Consultation Response from KC, Highways Development Management
2024/92281 Land adj, 17, Whitehall Road West, Birkenshaw, BD11 2LS
Erection of 23 dwellings
Date Responded: 28-11-2024. Responding Officer: Mark Berry Responding Ref: 8-10NW-10.
This application seeks approval to the erection of 23 dwellings at land adjacent 17, Whitehall Road West, Birkenshaw. The site access has previously been approved by application number 2020/92802 for 11 residential units (10 new plus one existing). The proposals are for a total of 24 units from the same point of access as previously approved by the 2020/92802 permission. The application is supported by a Transport Assessment (TA) prepared by Development Planning Ltd. This includes an assessment of the anticipated traffic generation as follows The TRICS database has been used to assess the anticipated traffic generation for the proposed 24 units (23 new plus one existing). The forecast two-way peak hour AM and PM traffic flows are 16 and 22 trips, an increase of 8 and 12 trips compared to the previously approved application. The TA concludes that there are no reasonable highway reasons for refusal of the application. Highways Development Manageme

CLIENT:	ORION HOMES		
PROJECT:	LAND ADJACENT TO 17 WHITEHALL ROAD WEST		
TITLE:	SWEEP PATH ANALYSIS REFUSE VEHICLE ACCESS (EGRESSING)		
SCALE @ A3:	NTS	APPROVED: DRS	DATE: 27/06/2024
PROJECT No:	2024376	DRAWING No: DPL SK007	REV: A
© Development Planning Limited

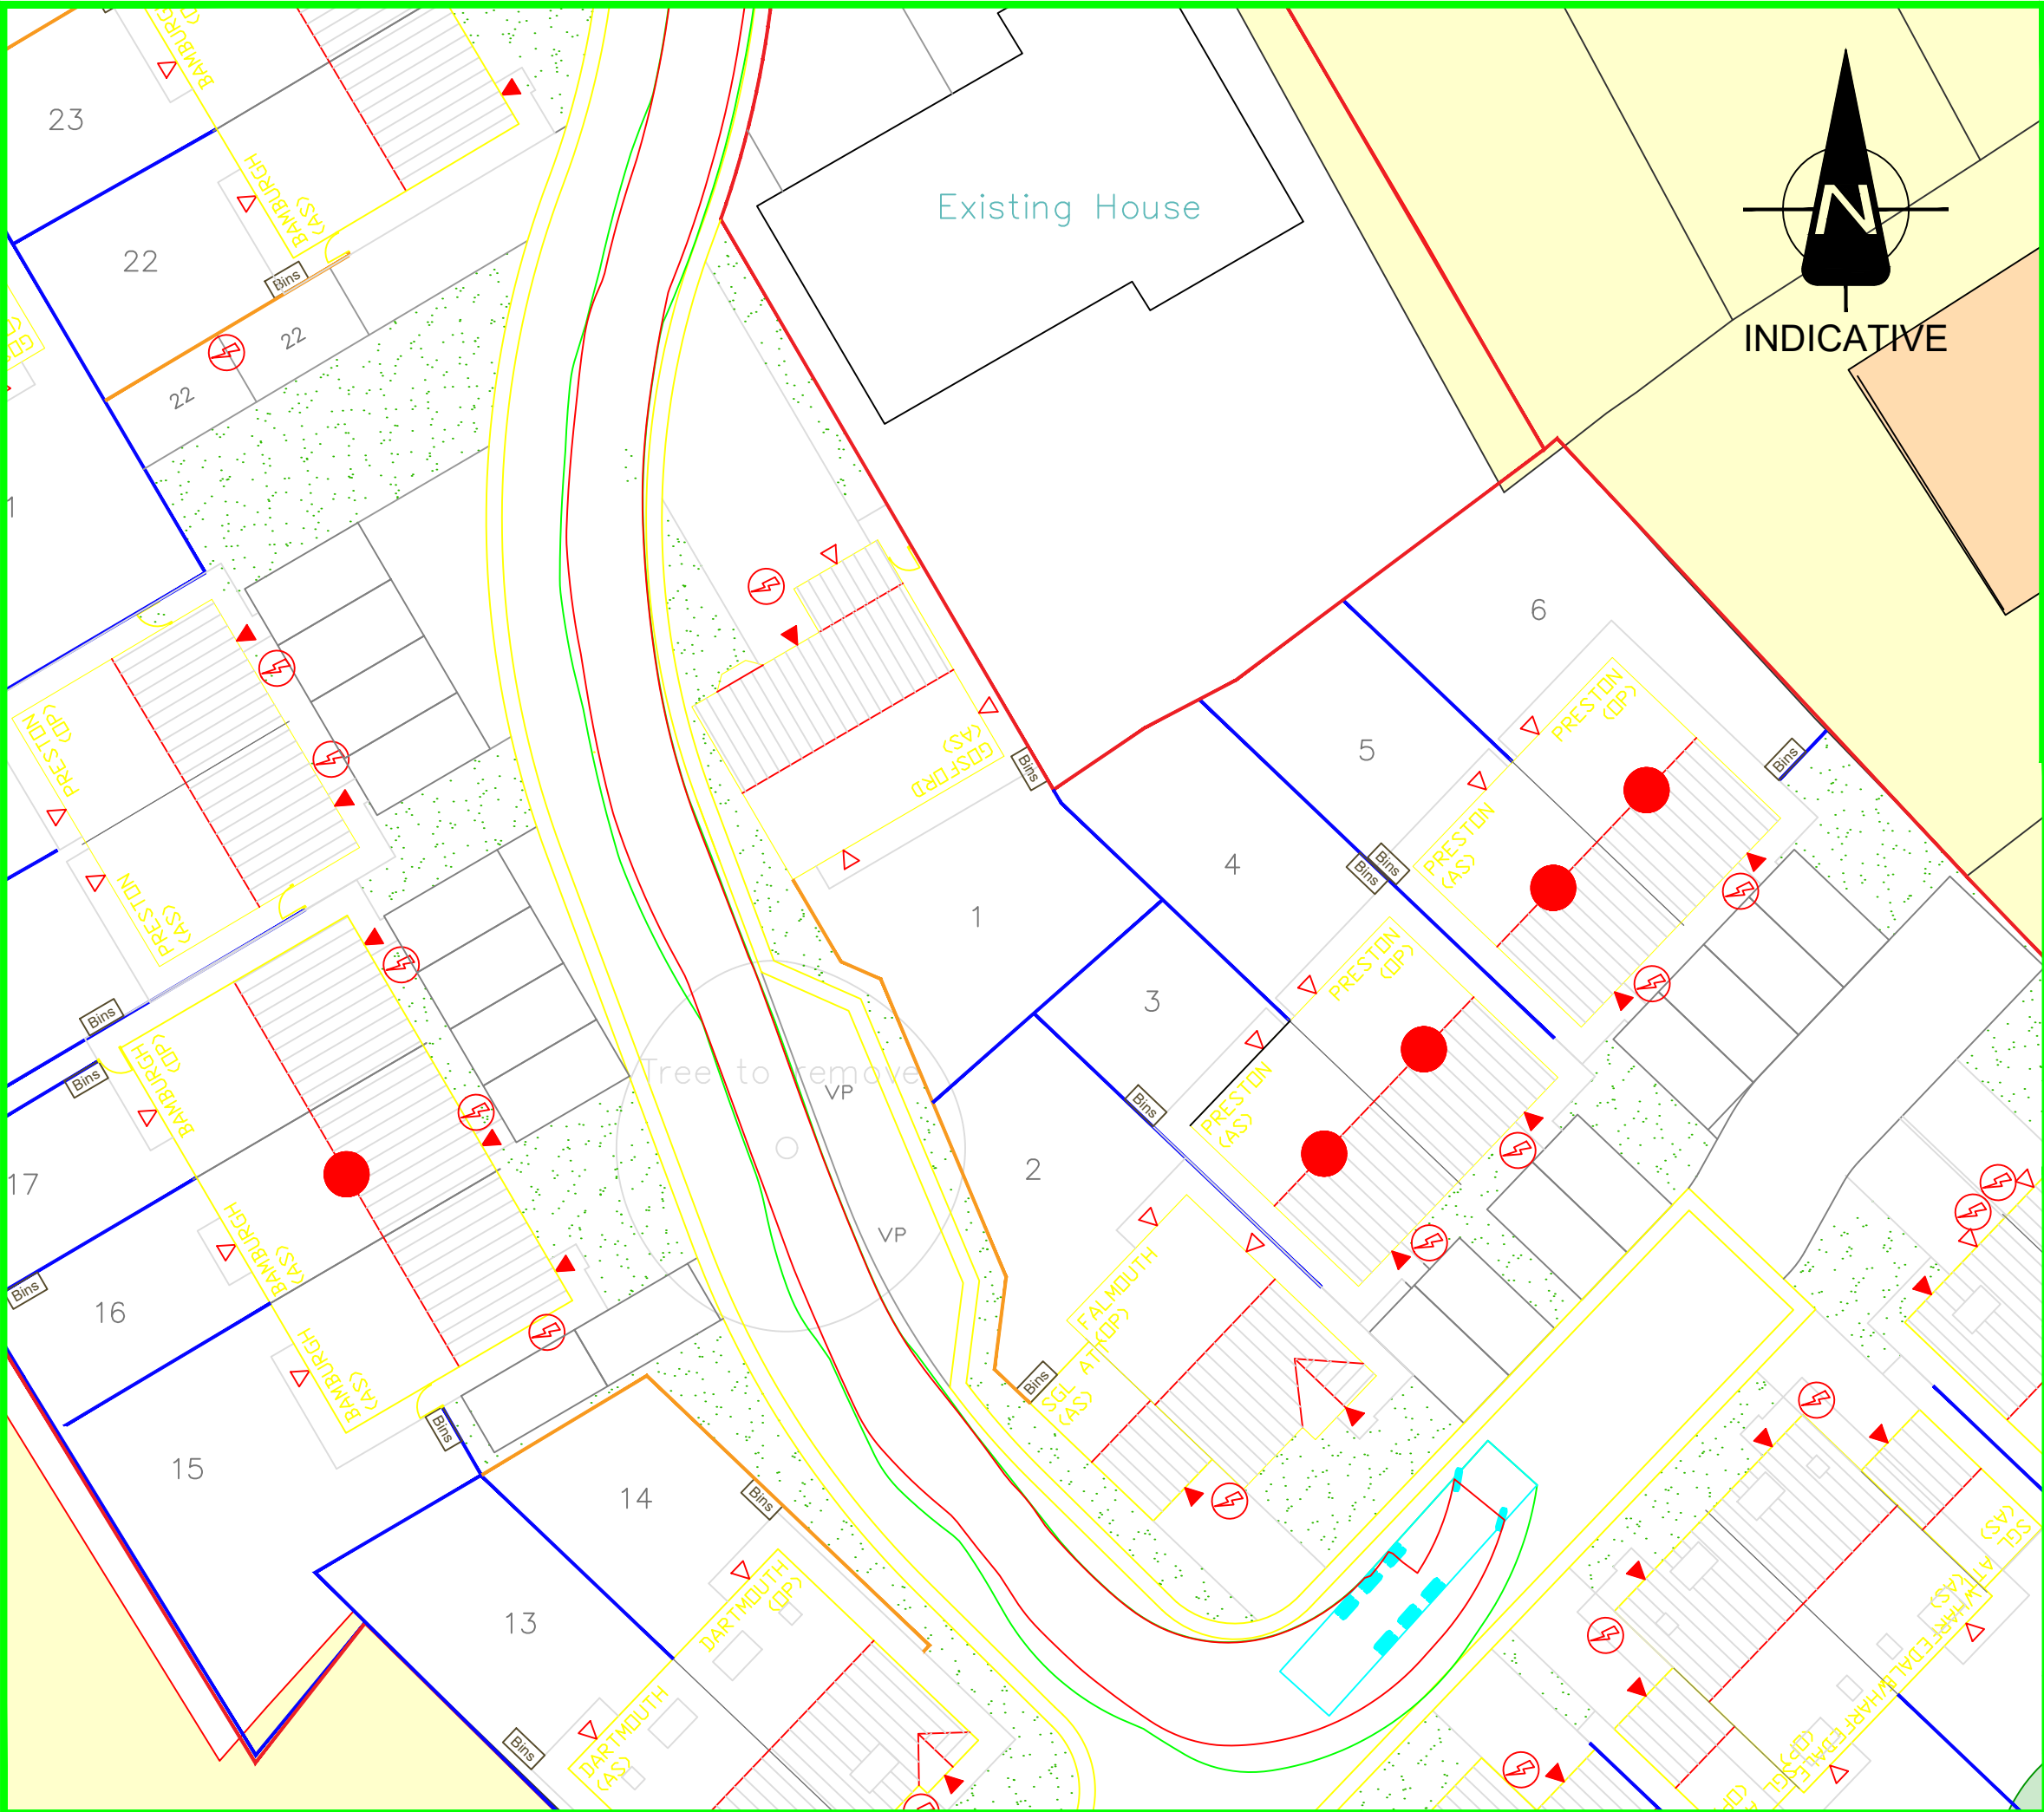
minimum standards.

Can the applicants also confirm the vehicle speeds when manoeuvring RCVs, shall be able to travel at a minimum speed of 5 km/h forward and 2.5 km/hr reverse. In other words, drivers shall not need to stop to adjust the steering while stationary before setting off again.

Site 1
Location Whitehall Road - 53.745939, -1.694896
Direction East

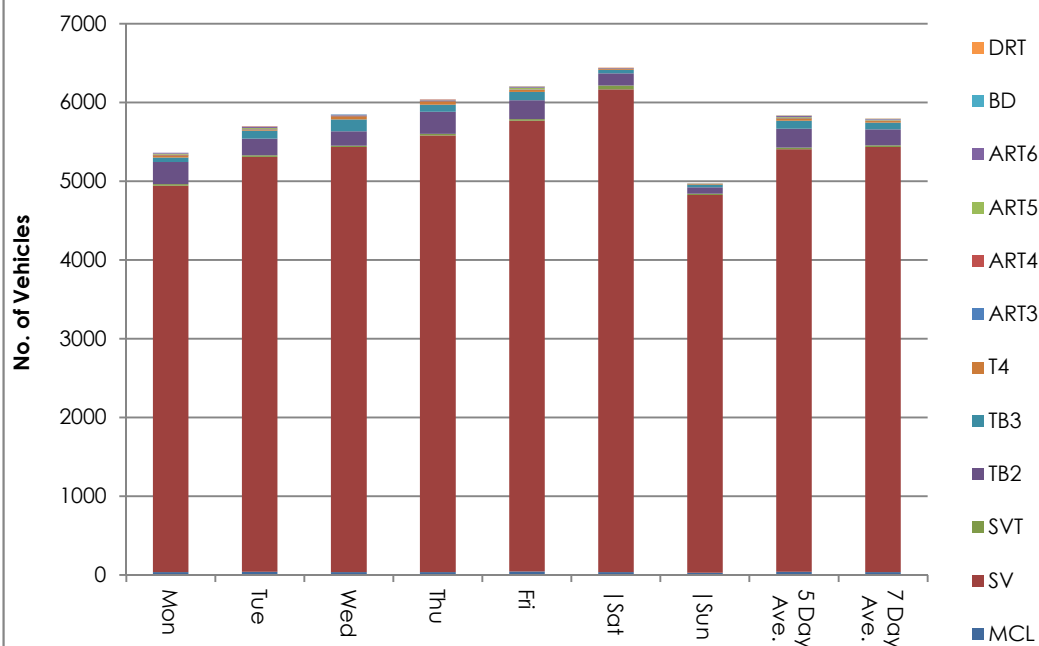
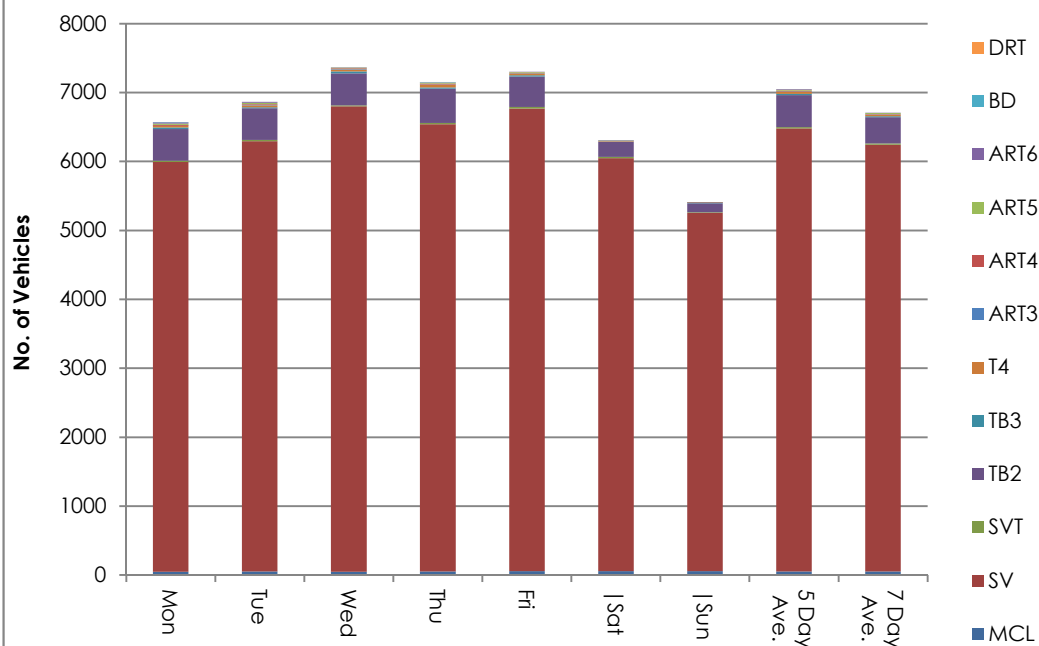
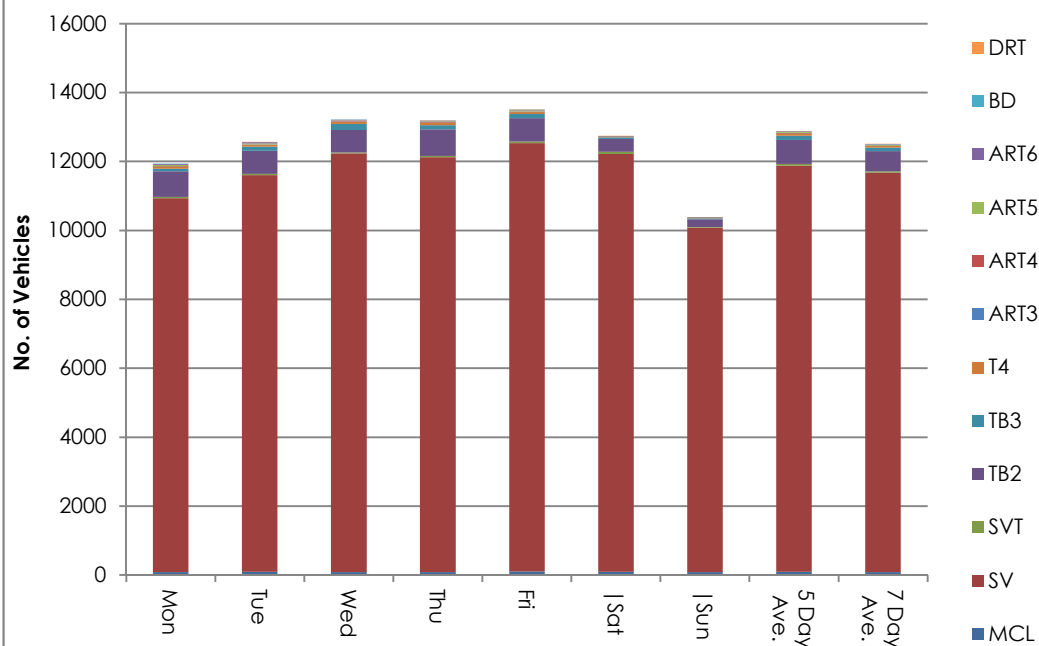
6, Sight lines of 2.4m x 46 m were required by condition 3 of the previous application. These were based on speed surveys that were undertaken in June 2020 which are now considered to be out of date. Further up to date speed surveys are therefore required. (Note also that wet weather speeds are no longer accepted).
